The NewHeight Group

October 6, 2017

Re: Luminato Condominium, LLC
Proposed Additional Minor Amendments to Approved Site Plan

SITE PLAN

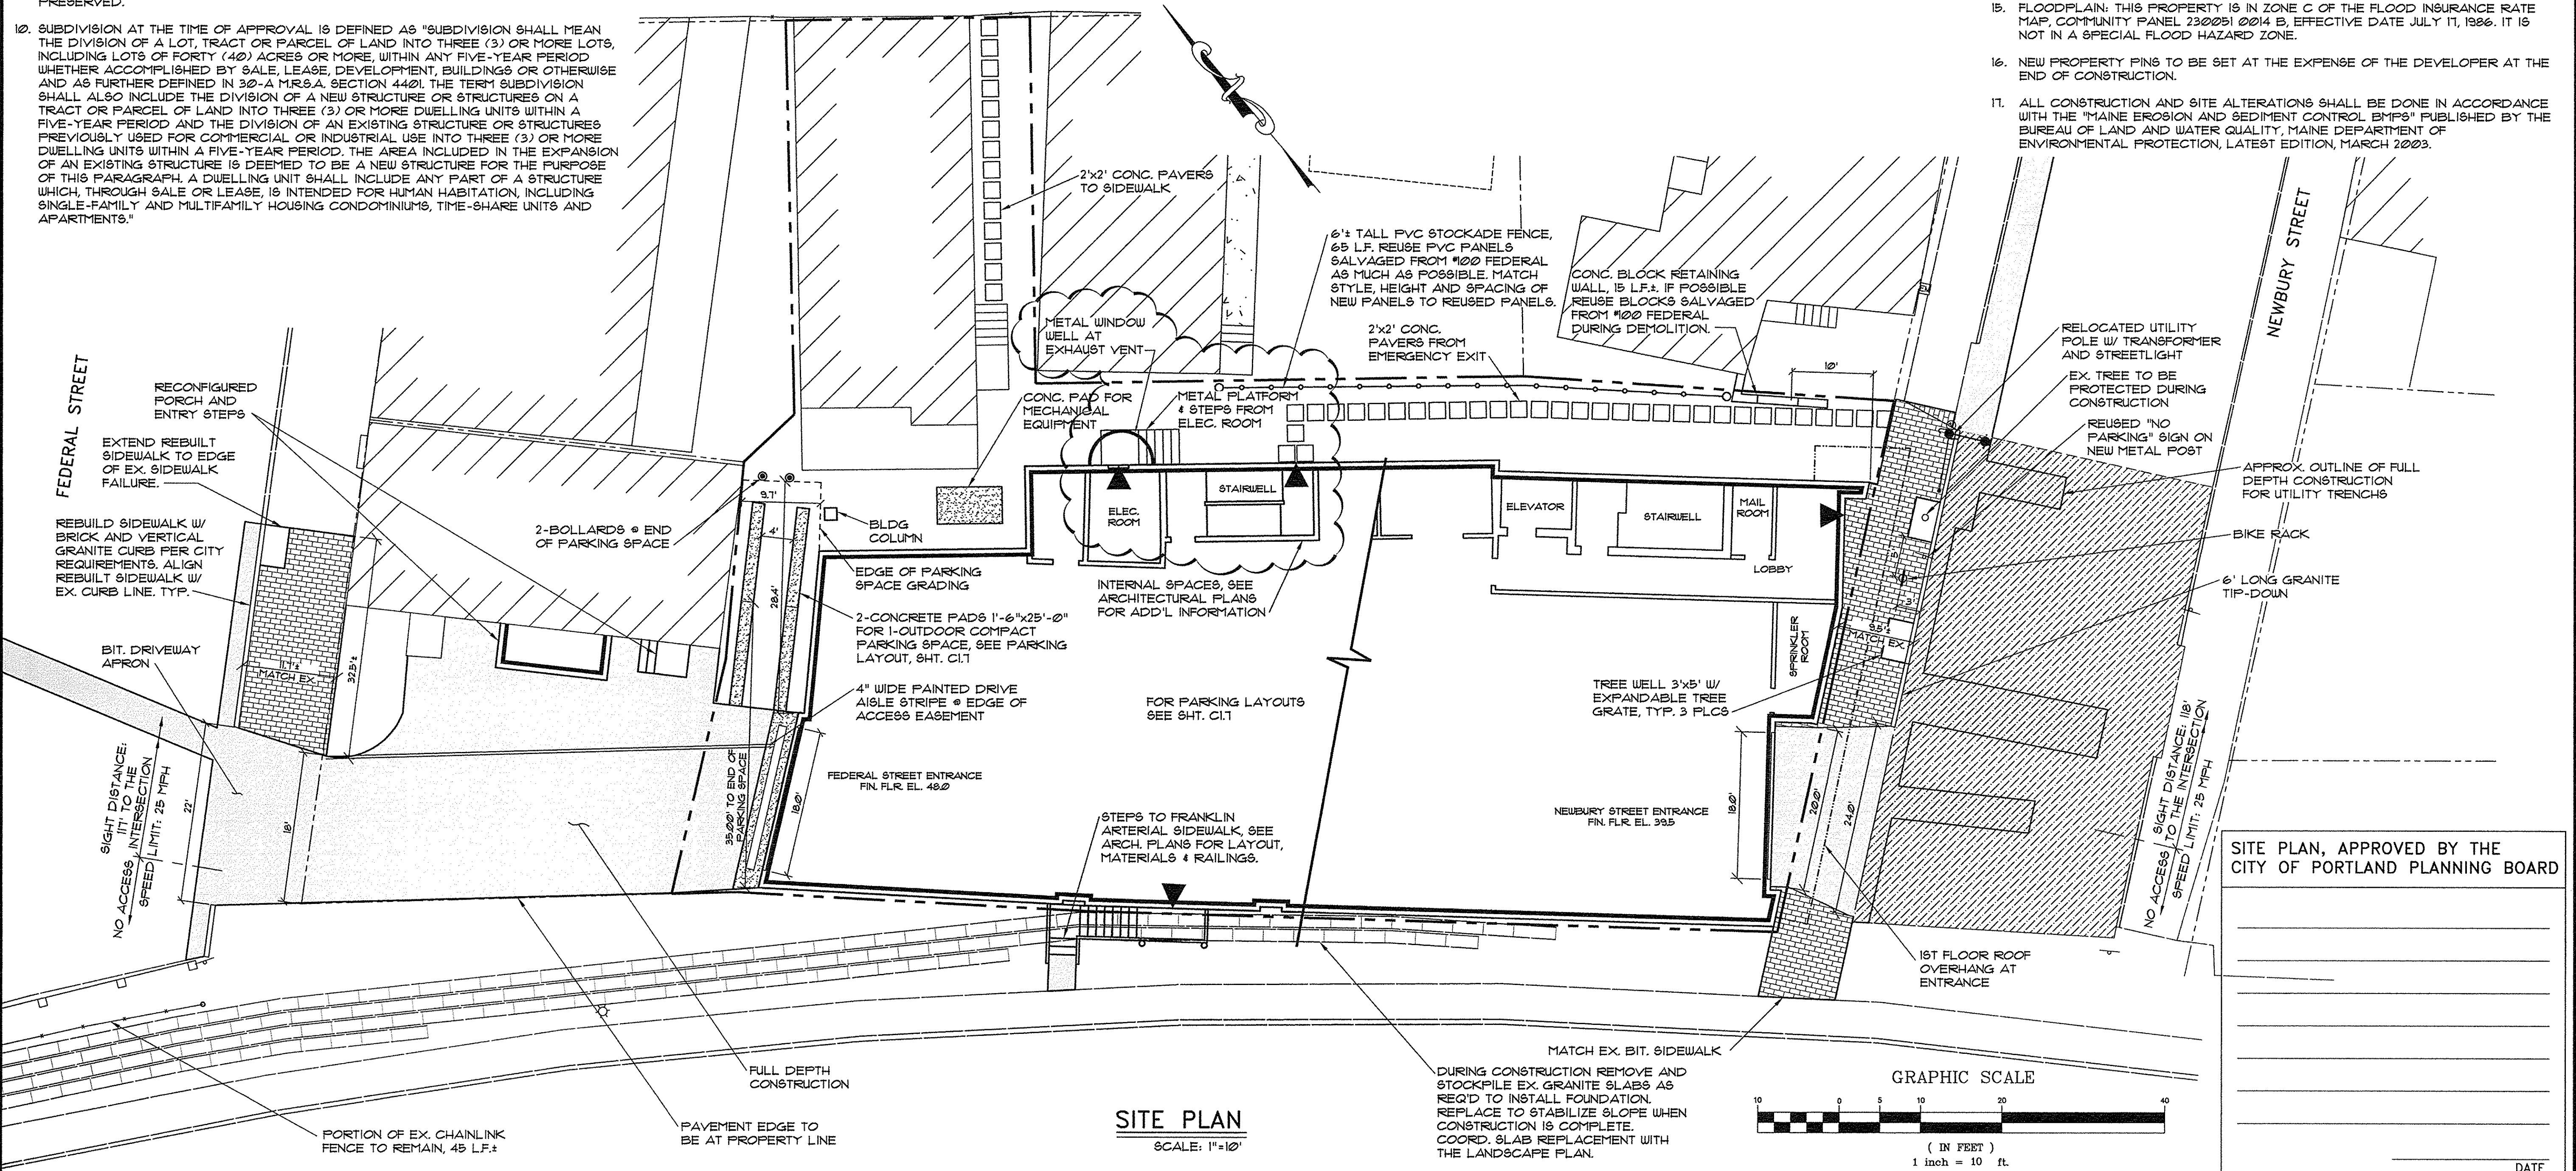
The approved Site Plan calls for removal and stockpiling of existing granite slabs along Franklin Street, and replacement to stabilize slope when construction is complete. We are proposing to eliminate these slabs in the area to the right of the new building entrance on Franklin Street as viewed from the City sidewalk. The grade here is flat, so they are not needed to stabilize the slope, and they are proposed for use elsewhere on the site (at the end of Newbury Street).

The approved Site Plan also shows a concrete block retaining wall between 167 Newbury Street and the abutting parcel at 32 Hampshire Street. The building at 32 Hampshire Street was recently sold, and the building demolished. The retaining wall was a part of the structure, and demolished and removed with it. The grade in this location does not require a retaining wall.

Finally, the approved plan calls for a 6-foot tall PVC stockade fence (reusing salvaged panels) 65 feet in length behind the building, separating Luminato from the properties at 32 and 36 Hampshire Street. By agreement with the abutters, we are proposing to install an 8-foot tall, wooden stockade fence approximately 30 feet in length across the back of the 36 Hampshire Street property, ending at the property line between 36 and 32 Hampshire streets.

Pinkham & Greer has revised plan sheet C1.2 of the approved plan set and uploaded them to the project's E-Plan account. Please let me know if you have questions or require any additional information in order to consider this request. Thank you for your time.
